CITY OF PORTLAND BUILDING PERMIT

PERMIT ID: 2013-00058

has permission to **Complete rehab. of 3 floors and repair porch.**

Proposed Use: 2 Family	Proposed Project Description: Complete rehab of 3 floors; remove/replace porch & build full dormer on right side
----------------------------------	--

IF THIS SHEET IS NOT 24 X 36 IT IS A REDUCED SCALE PRINT - SCALE ACCORDINGLY

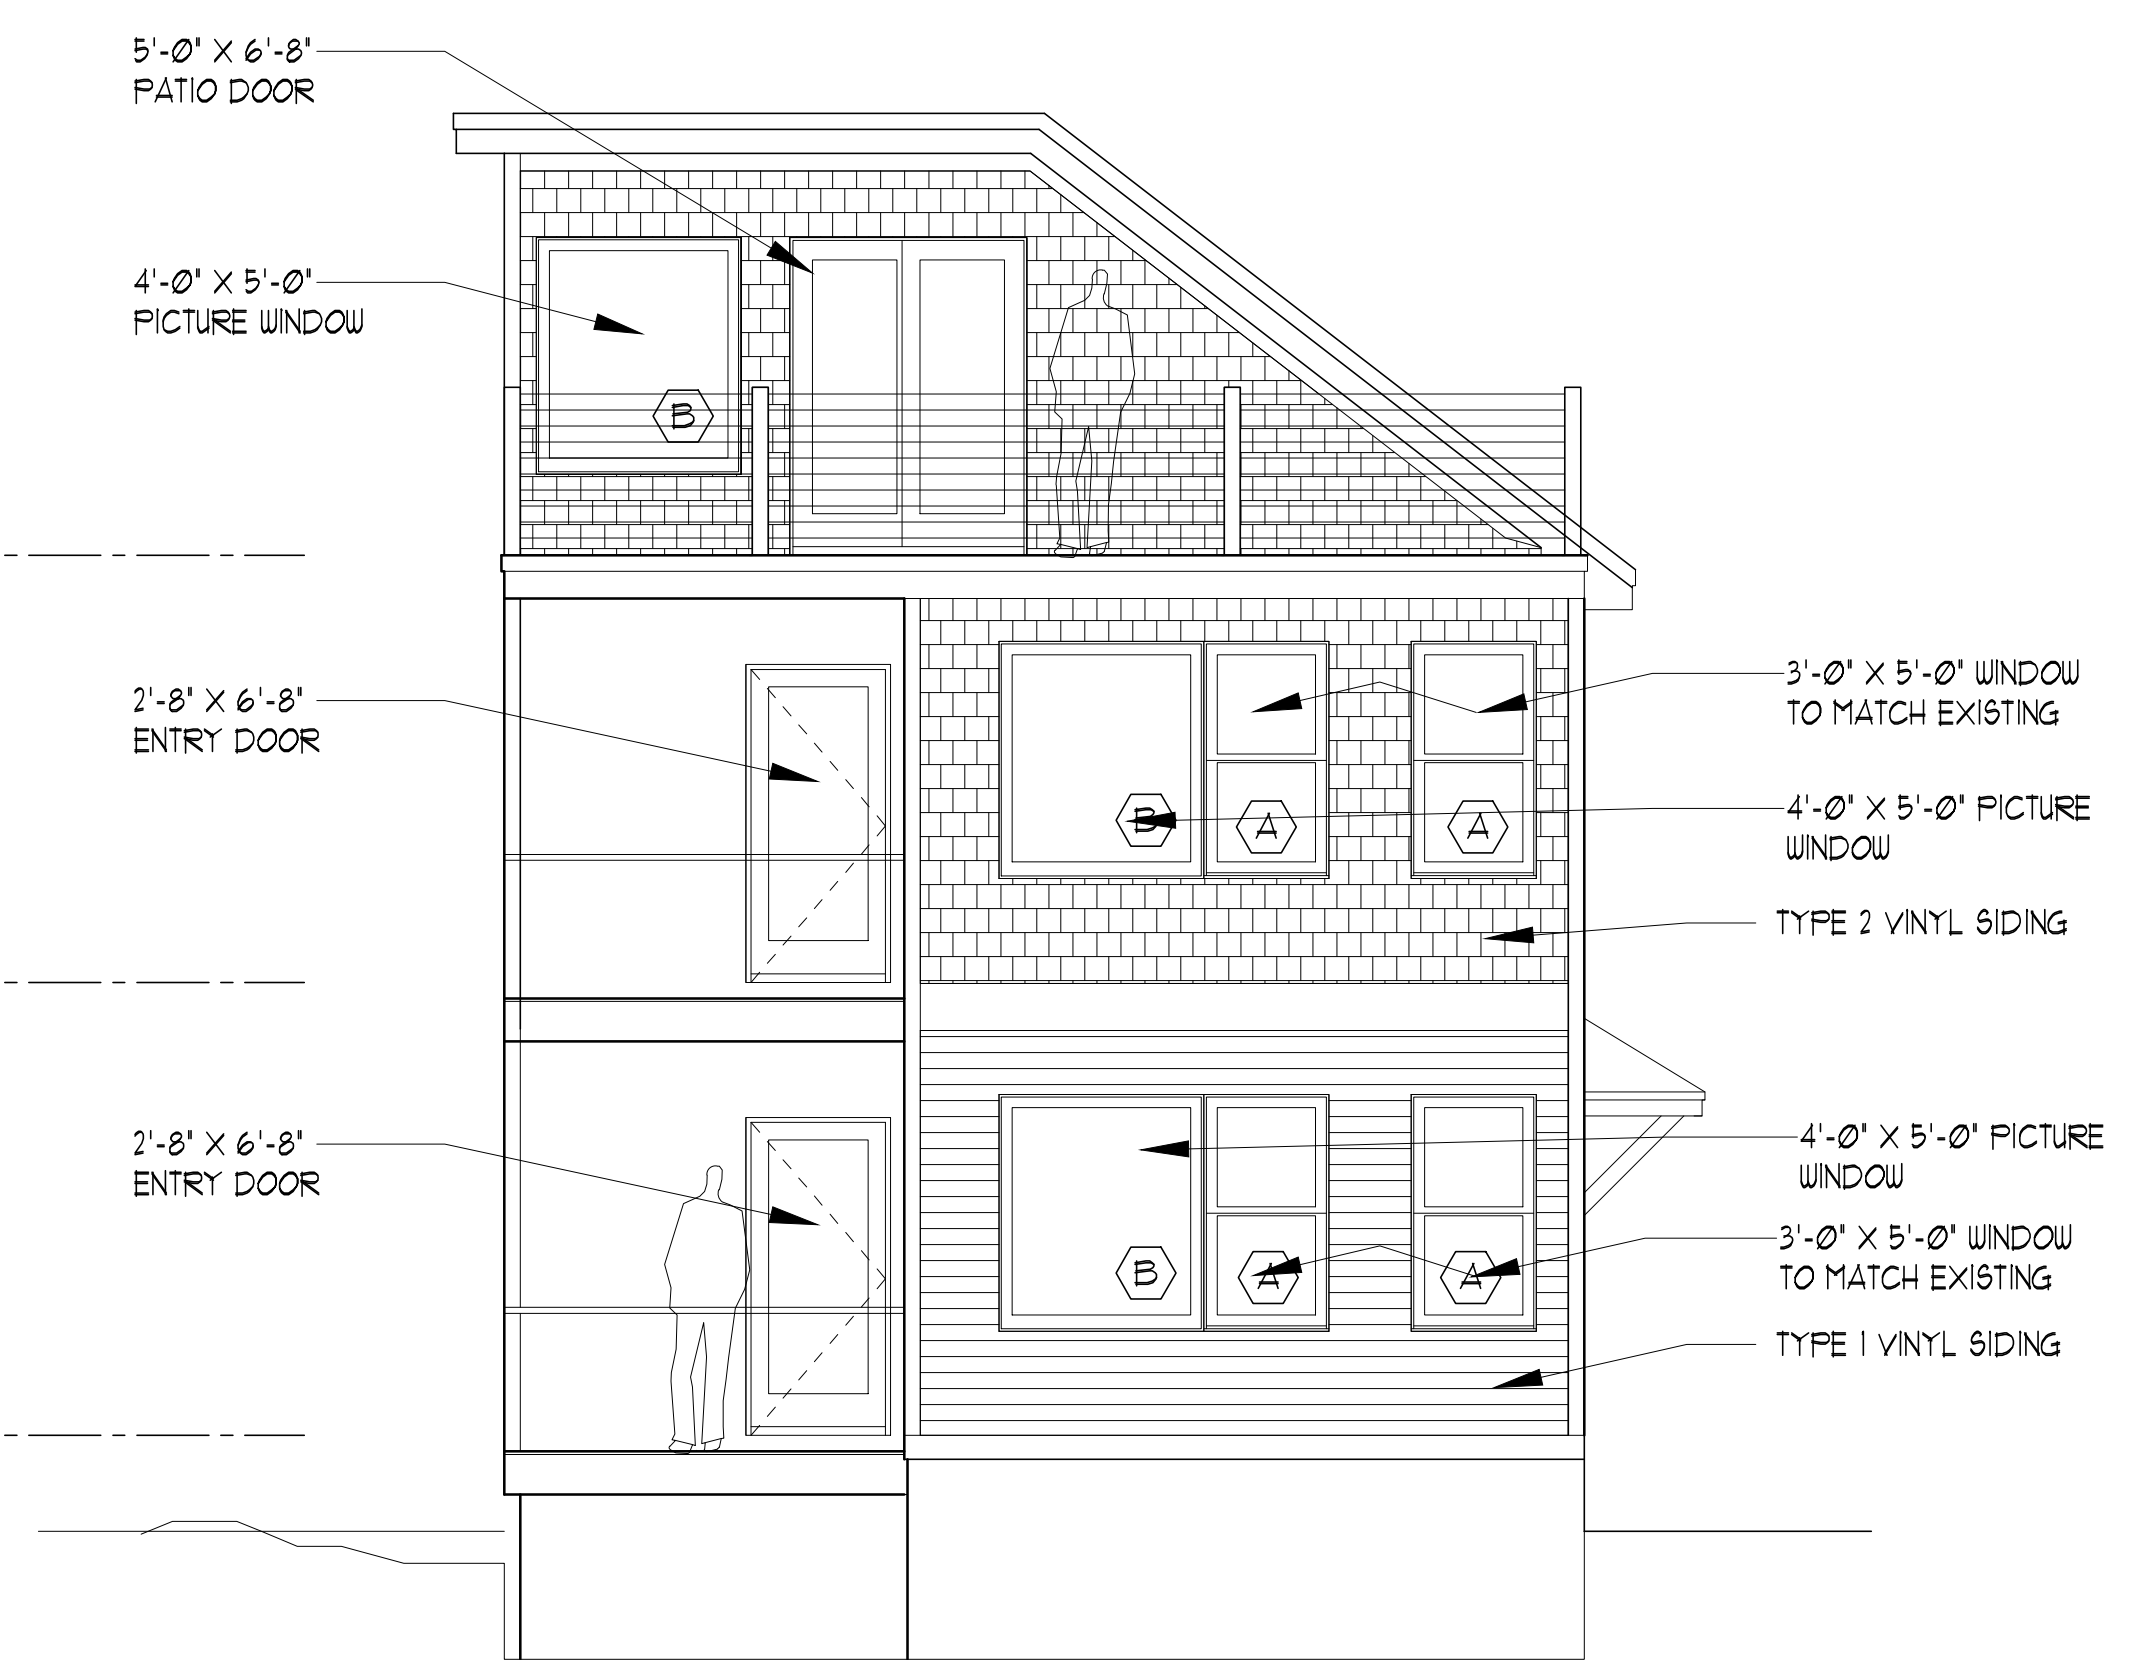
Note: The dormer is being allowed under section 14-436(a). The first floor footprint is 989 sf. The dormer is adding 216 sf. This is a 21.8% increase in floor area. The section allows a 50% increase. **Ok to Issue:**

4 HANDRAIL DETAIL
SCALE: 1 1/2" = 1'-0"

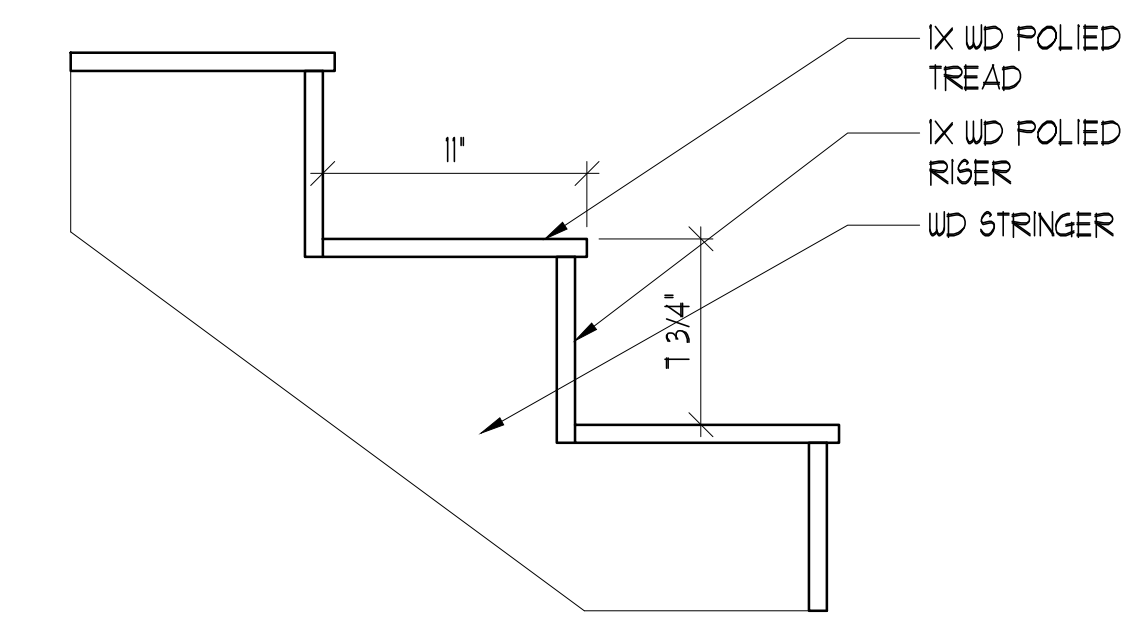
8) A graspable handrail (34-38 inches in height) shall be provided on at least one side of each continuous run of treads or flight with four or more risers. Fall protection (36 inches) from exterior decks may be required if floor joist are at or above thirty (30) inches from grade.

2 TYPICAL INTERIOR STAIR
SCALE: 1 1/2" = 1'-0"

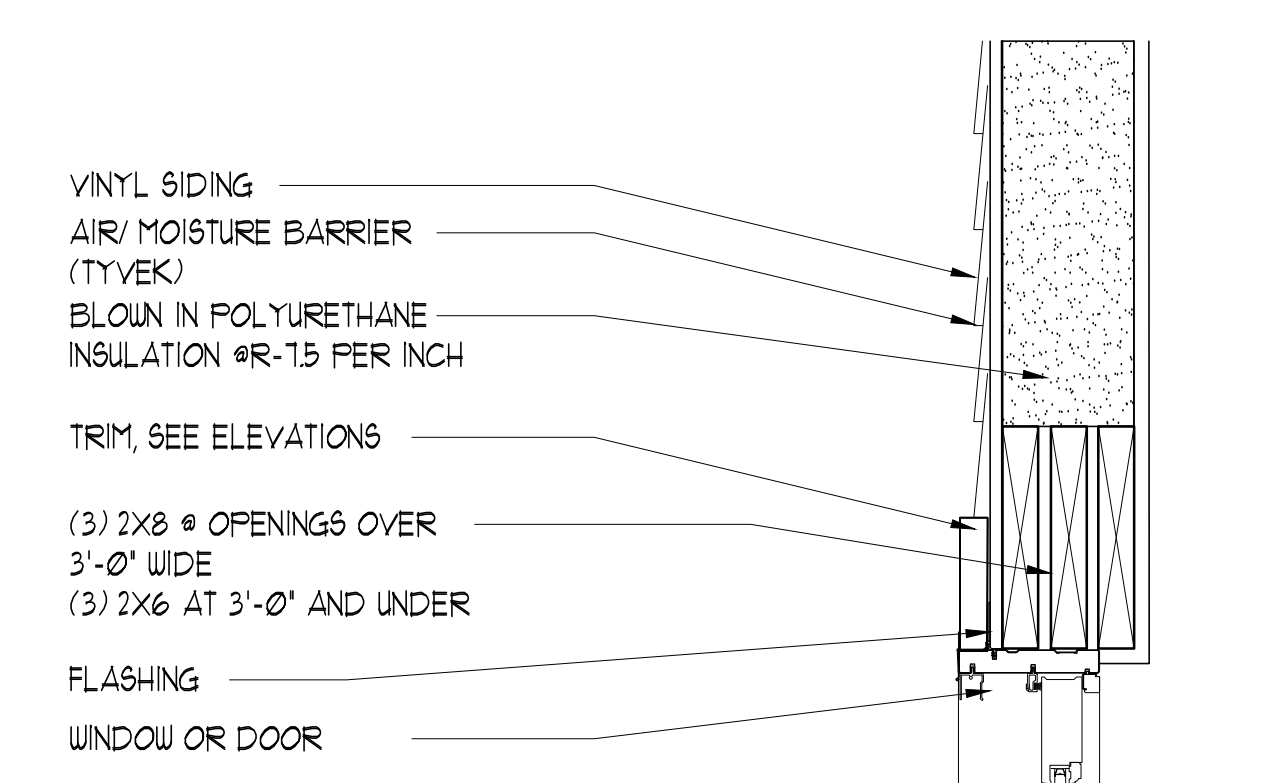
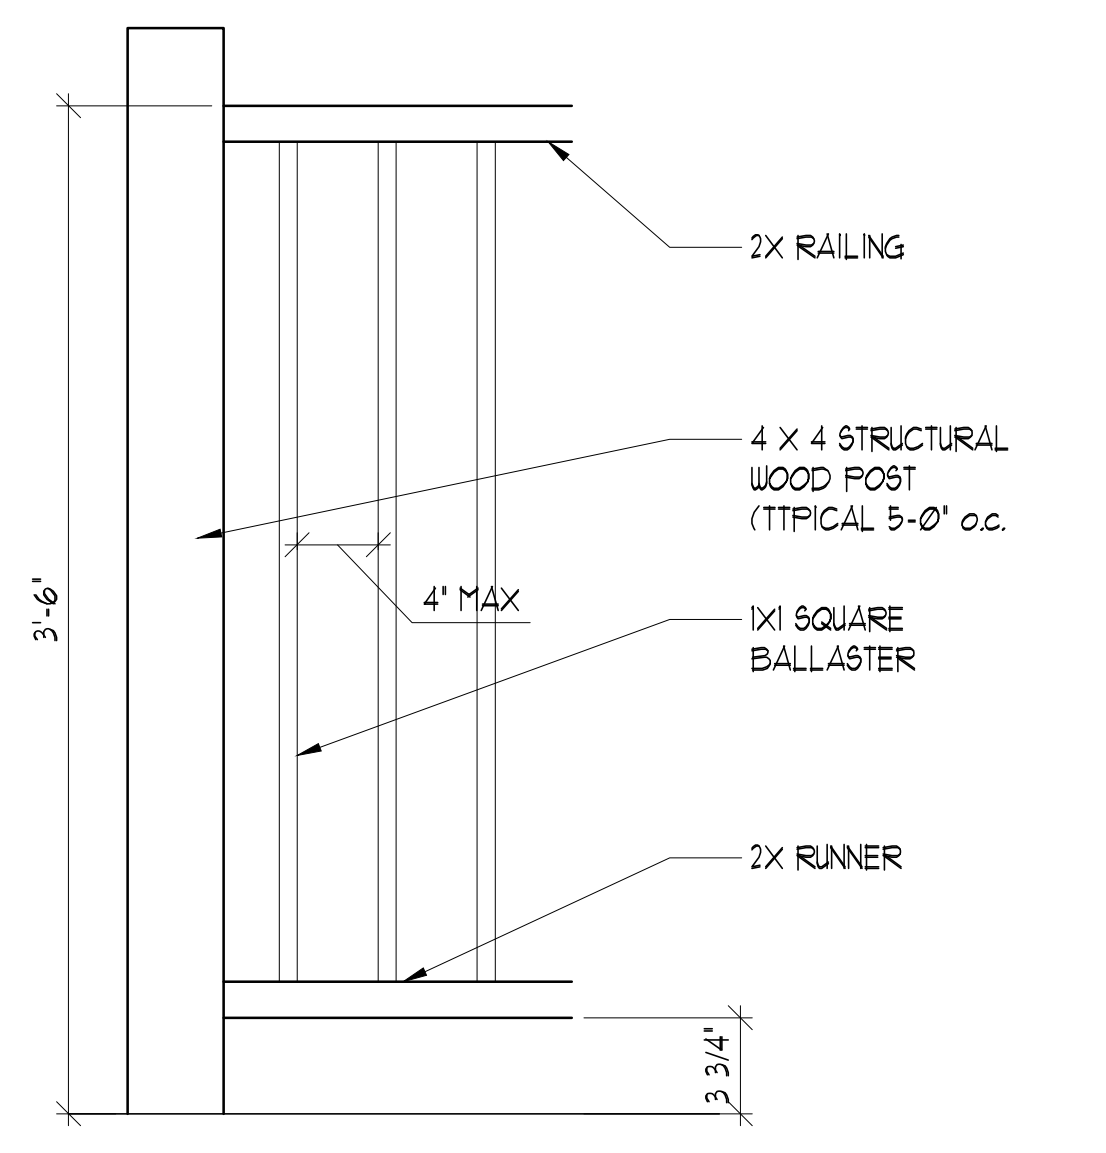
- 3) R311.7.1 Width. Stairways shall not be less than 36 inches in clear width at all points above the permitted handrail height and below the required headroom height. Handrails shall not project more than 4.5 inches on either side of the stairway and the minimum clear width of the stairway at and below the handrail height, including treads and landings, shall not be less than 31 1/2 inches where a handrail is installed on one side and 27 inches where handrails are provided on both sides.

Stairway headroom shall be not less than 6 feet 8 inches measured vertically from the sloped plane adjoining the tread nosing or from the floor surface of the landing or platform.

The maximum riser height shall be 7 3/4 inches; the minimum tread depth shall be 10 inches.
